From: Amanda Scholes on behalf of Planning.Responses
Sent: 12 January 2022 08:05
To: Planning Scanning
Subject: FW: A/235/21/DOC - Land off Arundel Road, Angmering

Please upload onto Ocella the email below which is a consultation response from **ADC Environmental Health** to discharge of condition application **A/235/21/DOC**.

I refer to The Design Code Masterplans, November 2021 and January 2022 prepared to allow discharge of Condition 5, A/207/21/PL. Also, the applicant's note (paragraph 3.2 page 23, November 2021) that 'the land use and design framework plans were prepared to demonstrate what could be achieved and must be recognised as provisional in the absence of technical constraints being further established and technical design being considered on the basis of these.'

Proposed land use plan

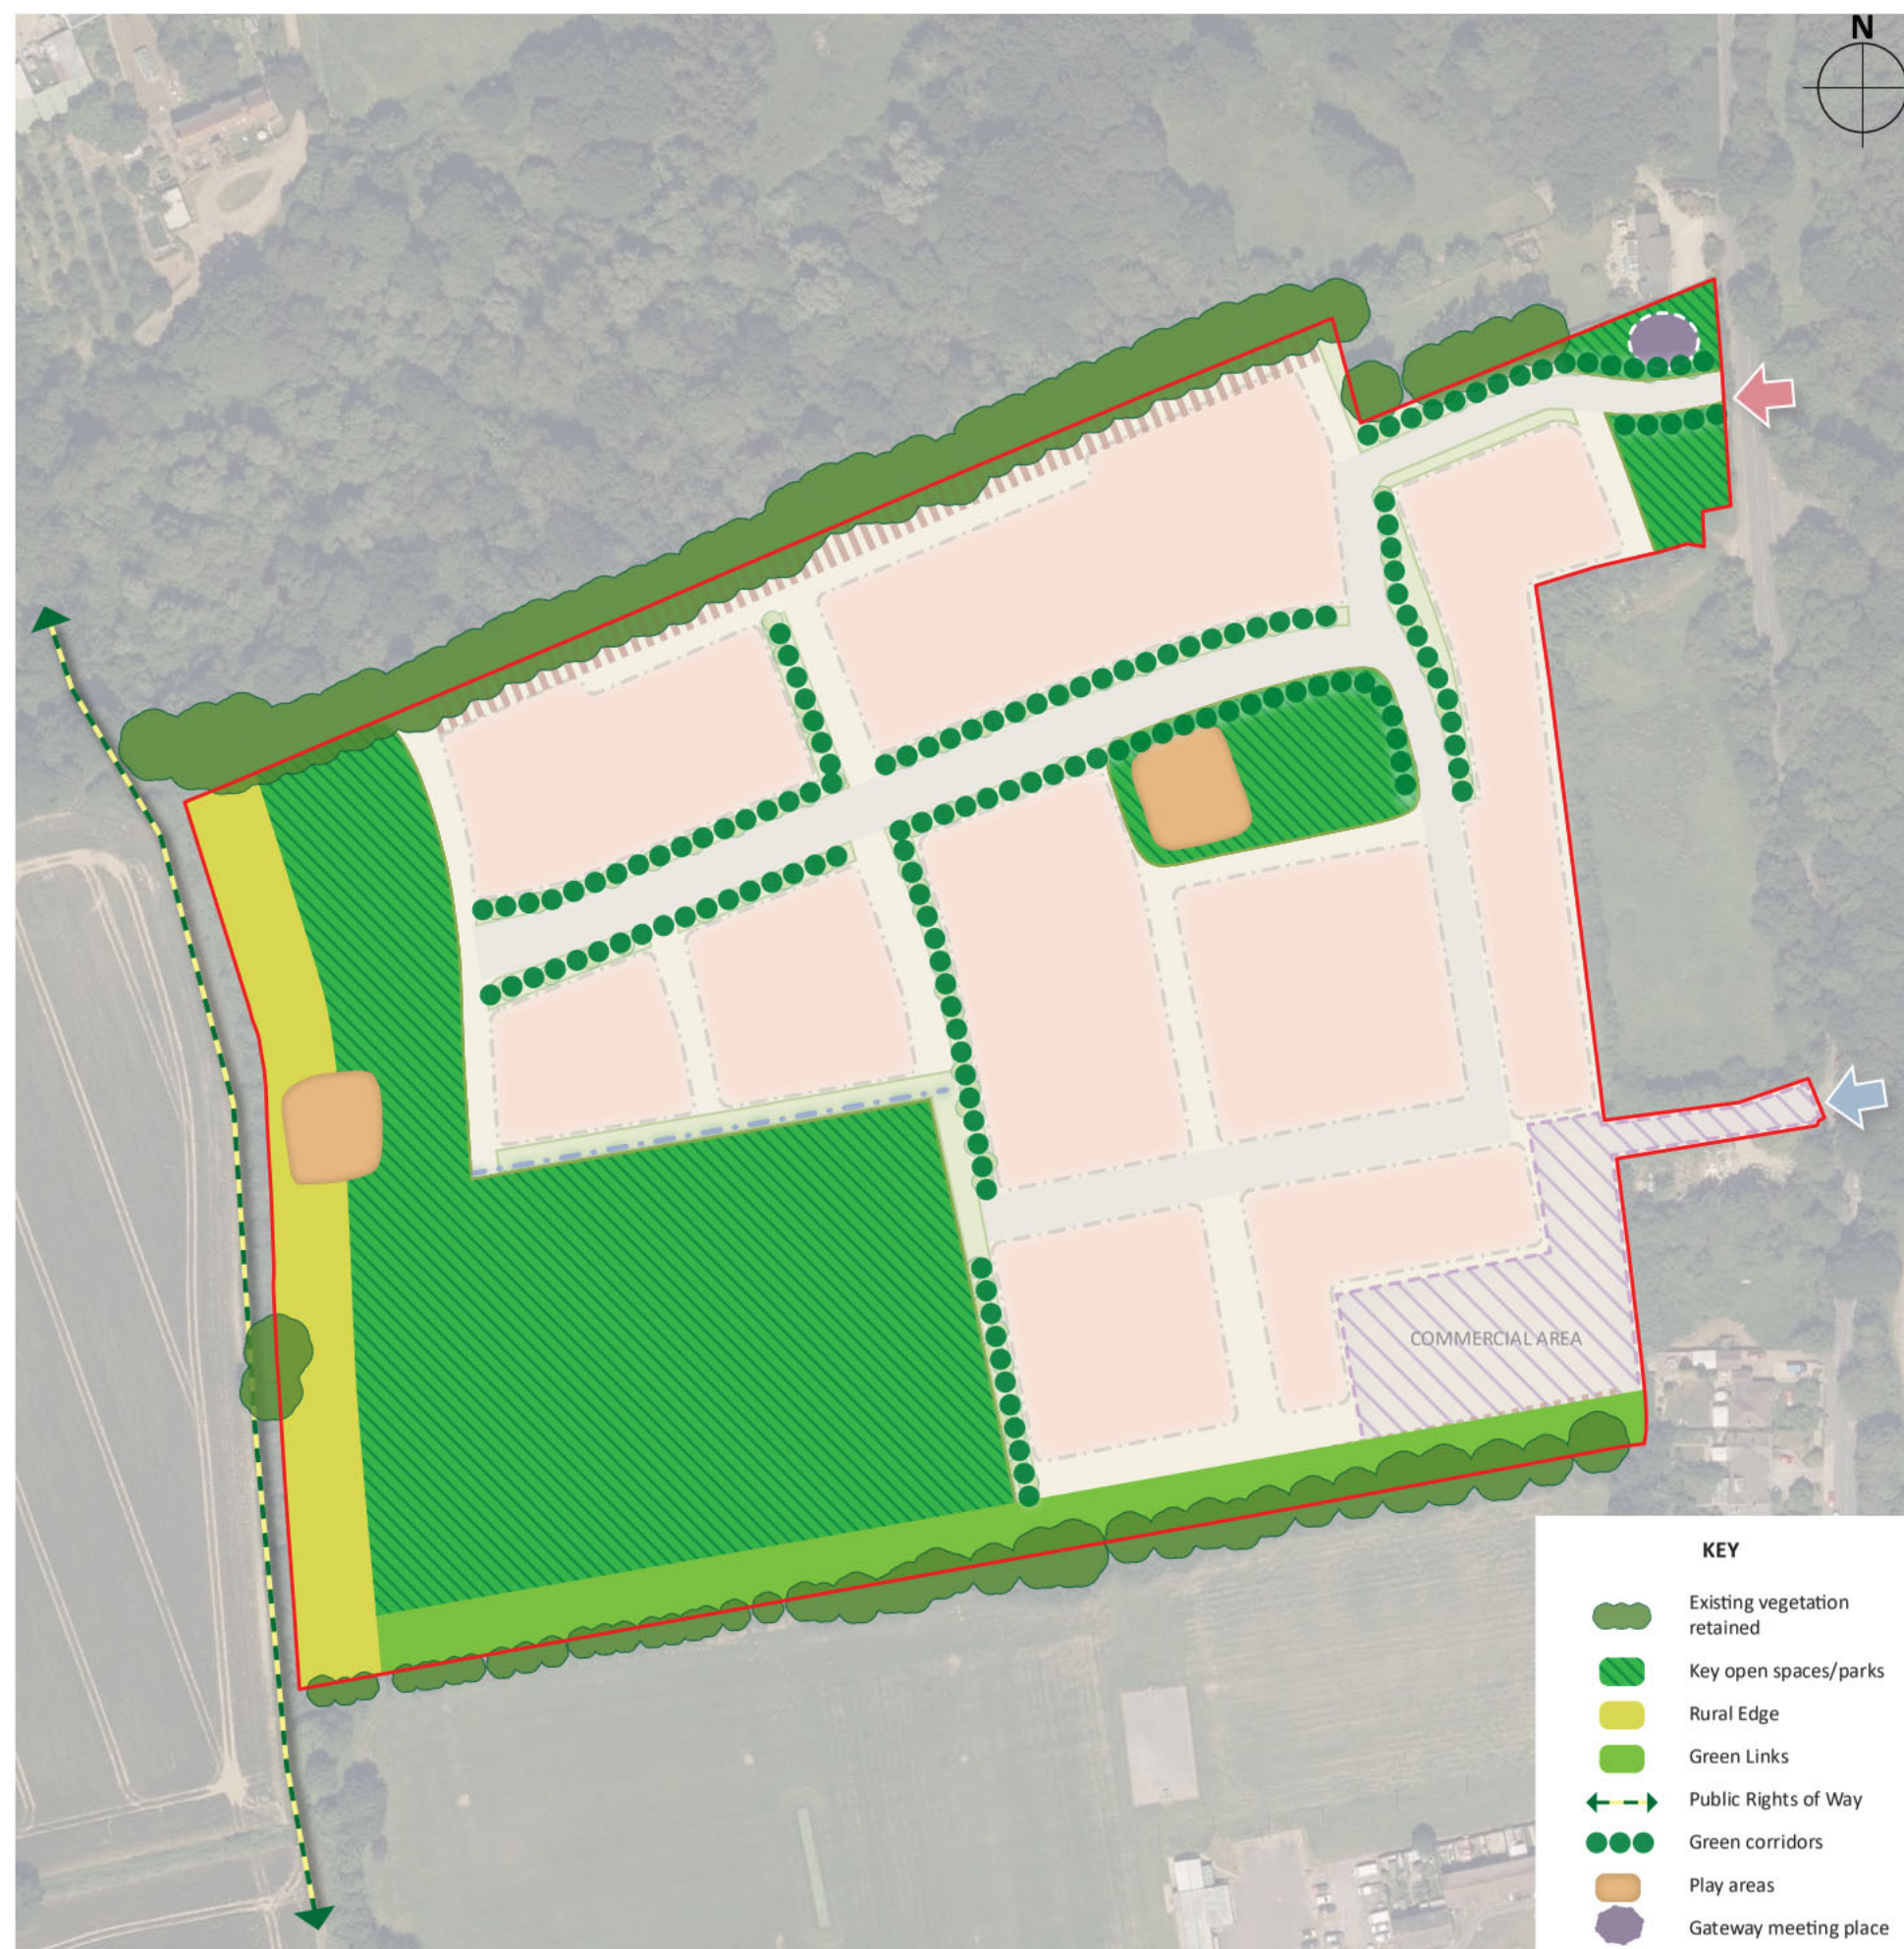
The November document refers to an area of swale, or hedgerow of undefined width, adjacent to the proposed sports pitches and although the January document details a buffer area (mostly to the Woodland Edge) this is in marked contrast to the wide buffer zone (and play area) provided to accompany the application for Outline Planning permission.

Ideally, the orientation and layout of the sports pitches would be finalised so that a meaningful noise (and lighting) report could be provided to inform the location and layout of the proposed new housing and any necessary noise mitigation to include buffer zones, etc.. Alternatively, the developer could provide a detailed layout of houses which will border the sports pitches, and it will be necessary to design the sports pitches in order to minimise potential adverse effect from noise and lighting from the new provision. Please see guidance provided by the Planning Noise Advice Document for Sussex: 2021.
